RE: Helley Boundary Line Adjustment, BL-10-00032

RE: Helley Boundary Line Adjustment, BL-10-00032

TO: Jeff Watson, Community Development Services
FROM: Christina Wollman, Planner II *ow*
DATE: August 5, 2010
SUBJECT: Helley BL-10-00032

EXHIBIT A

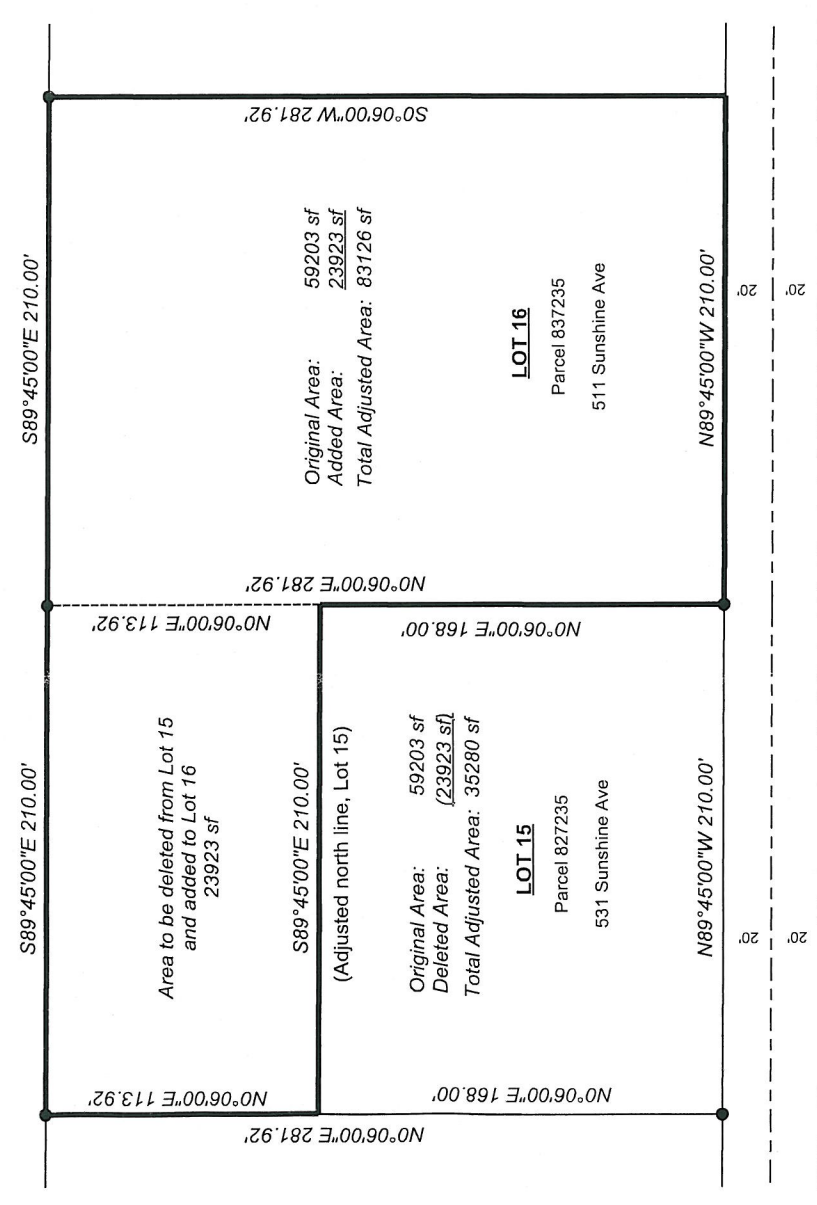
- All future development must comply with the International Fire Code.
- Ensure that boundary line adjustments do not infringe upon existing structures, to include propane tanks, etc.
- Creation of future lots will necessitate fire apparatus access requirements.

There are existing wells and on site sewage systems on both of these lots. The new lines must be the required 50 feet away and the locations of the septic systems need to be taken into consideration.
